Statement of Common Ground with Beverley and North Holderness Internal Drainage Board (draft)

August 2025

- 1.1.1 This Statement of Common Ground (hereafter referred to as the 'SoCG') has been prepared to support the Examination of the Development Consent Order (DCO) application (the 'DCO Application') for Peartree Hill Solar Farm (the 'Proposed Development').

#### Figure 3.6: Indicative Culvert Crossing Points

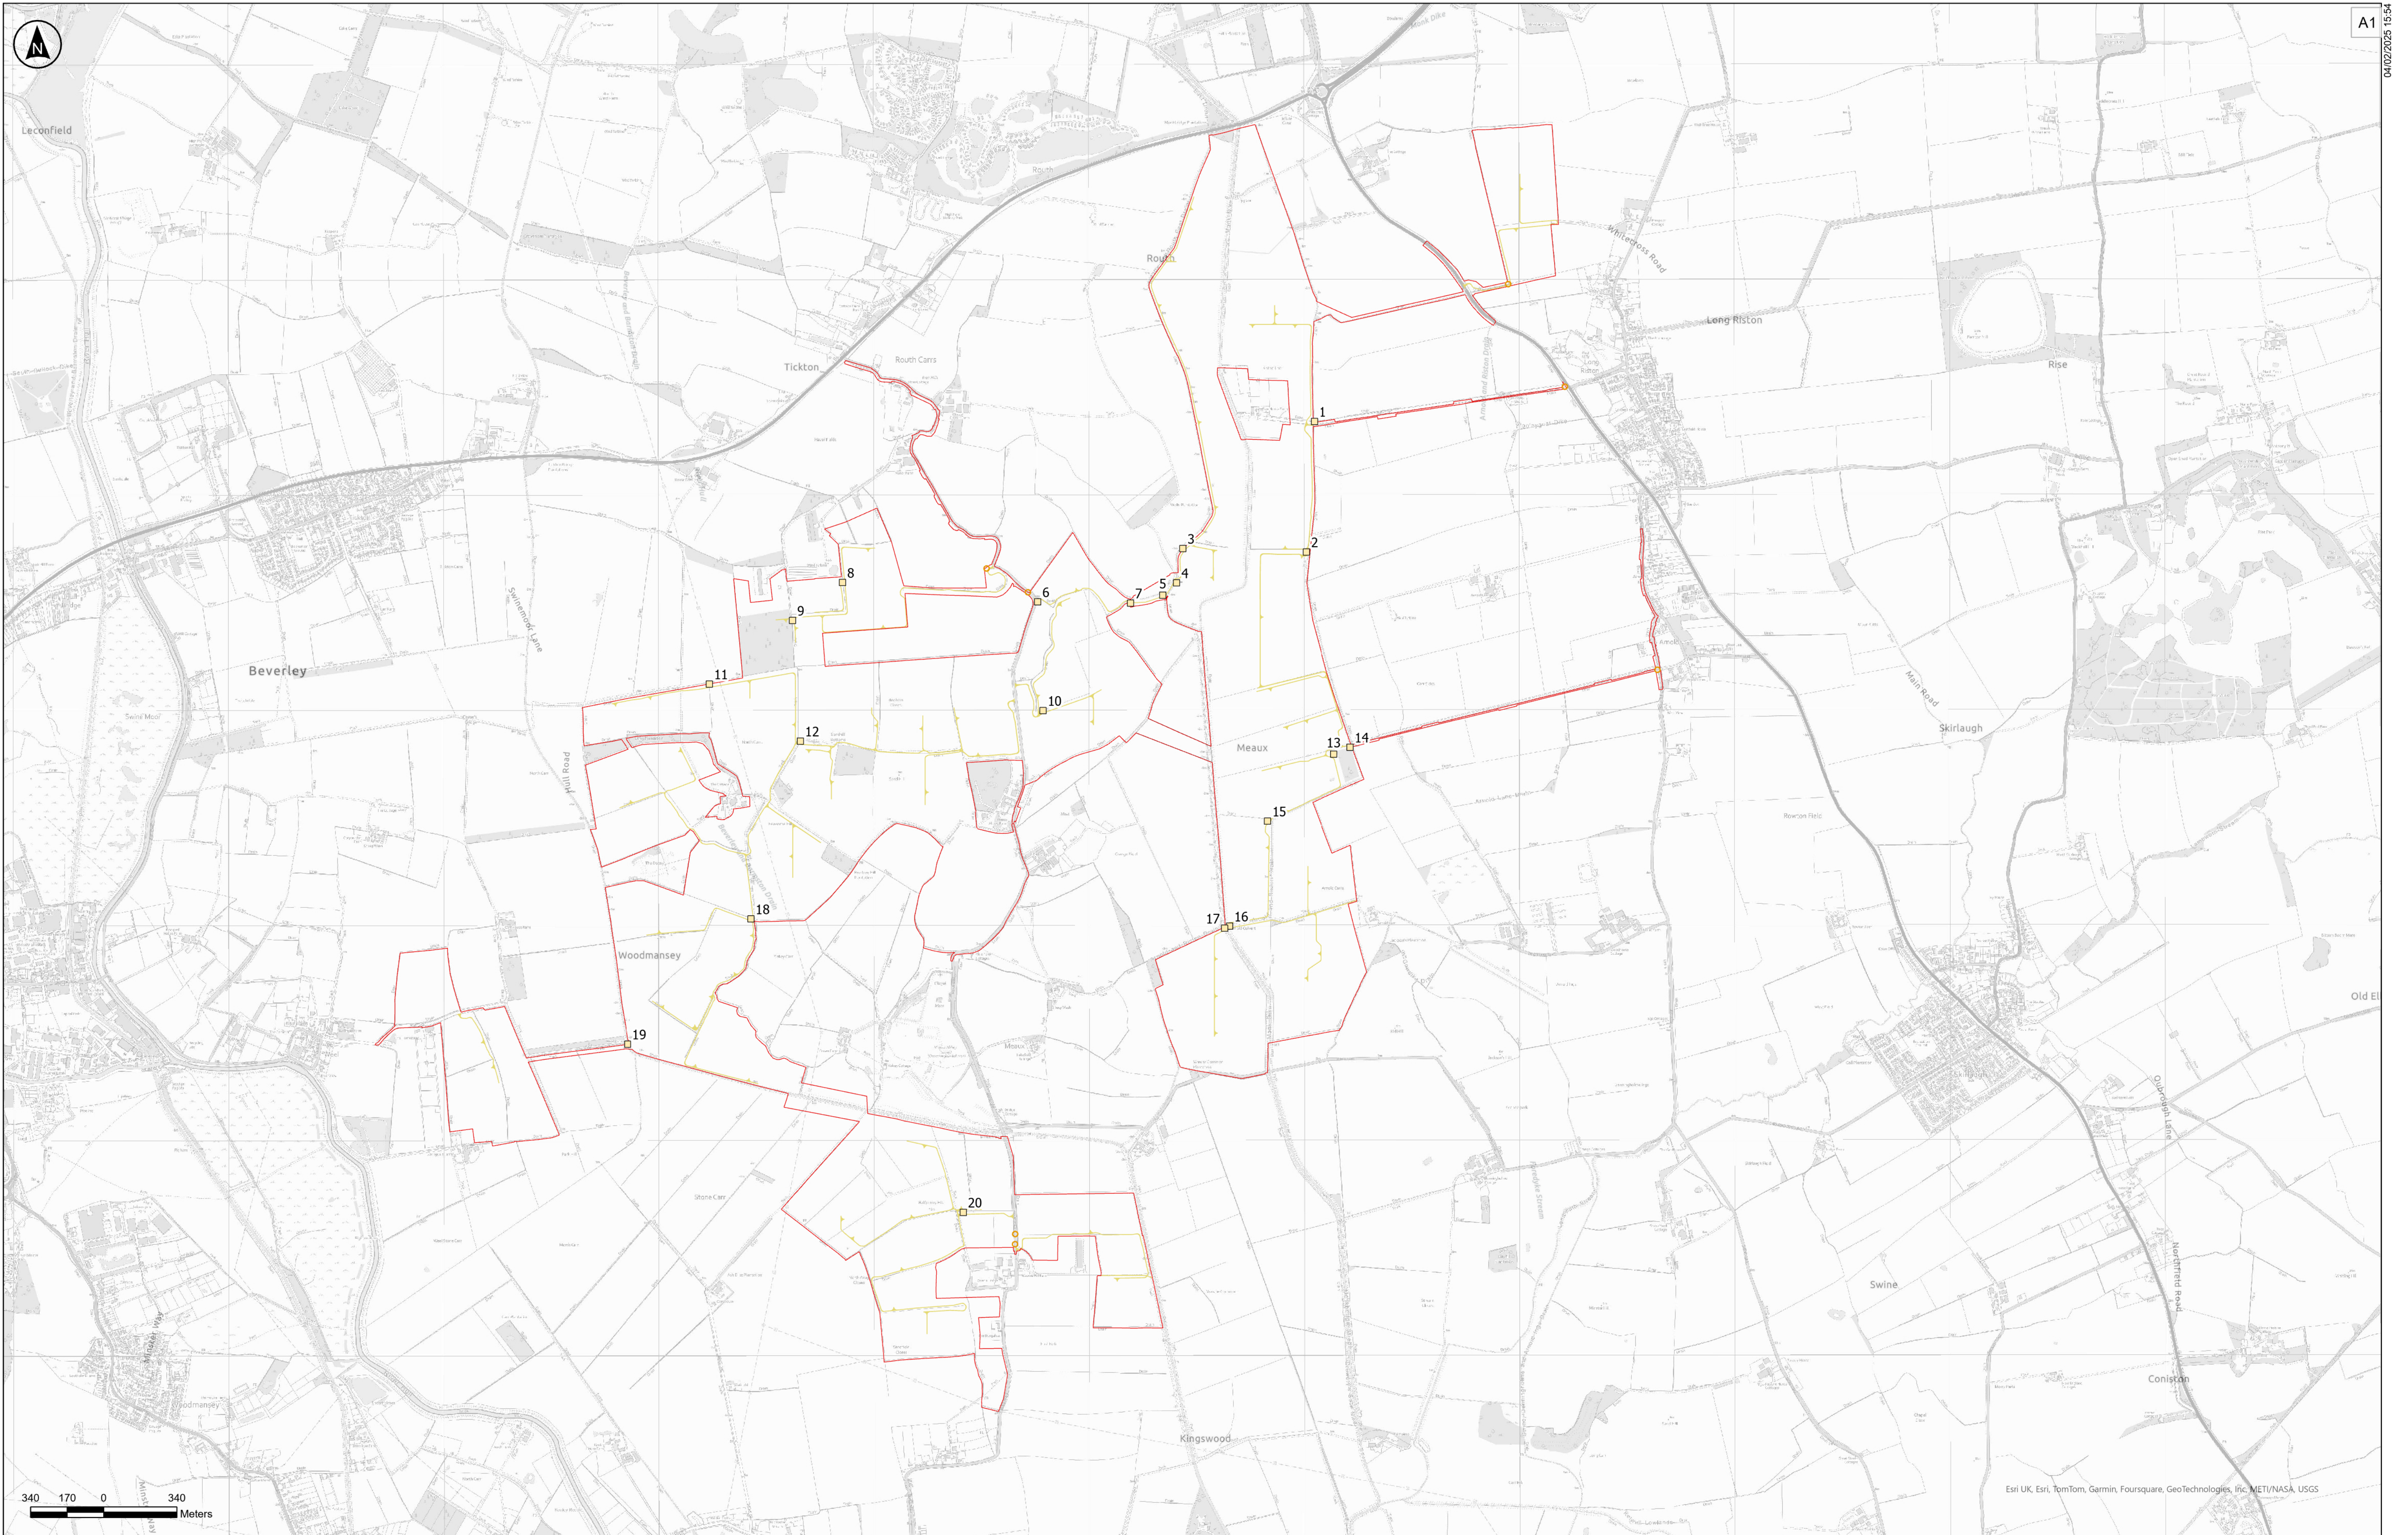
IDB02	Access tracks <i>Hydrology and Flood Risk</i>	In its relevant representation [RR-004] , Beverley and North Holderness Internal Drainage Board states that if Type 3 material (with a 30% voids ratio) is used for access tracks, this is viewed as "permeable" and not requiring a drainage strategy. If Type 1 materials or other impermeable materials are used, this is viewed as "impermeable" and requiring a drainage strategy.	Internal access track design, including materials, will be confirmed as part of the detailed design stage and submitted to East Riding of Yorkshire Council for approval as part of Requirement 3 of the Draft DCO [EN010157/APP/3.1 Revision 4] . The Applicant will continue to liaise with the Board on this matter.	Under discussion
IDB03	Bridge/ culvert crossings	In its relevant representation [RR-004] , Beverley and North Holderness Internal Drainage Board requests that details of any bridge/ culvert crossings over any	The Applicant agrees to this request. It is the Applicant's intention to utilise existing culvert crossings and/or bridge structures where possible. Pre-construction structural surveys will	Agreed

Ref	Topic	Beverley and North Holderness Internal Drainage Board Position	Applicant's Position	Status
	over watercourses <i>Hydrology and Flood Risk</i>	watercourses within its district will need to be discussed and agreed with the Board.	<p>be undertaken to determine the most appropriate crossing at each location (it is expected that the pre-construction surveys would result in the number of new crossings required to be lower than is shown on ES Volume 3, Figure 3.6: Indicative Culvert Crossing Points [APP-060]). Crossing design would be controlled by the protective provisions within Part 3 of Schedule 12 to the Draft DCO [EN010157/APP/3.1 Revision 4], which require plans to be submitted to the Board for approval at the detailed design stage.</p> <p>ES Volume 4, Appendix 5.6: Flood Risk Assessment [EN010157/APP/6.4 Revision 3] and ES Volume 4, Appendix 5.5: Water Framework Directive Screening and Scoping report [EN010157/APP/6.4 Revision 2] have been updated to clarify the approach to watercourse crossings and are submitted at Deadline 1.</p>
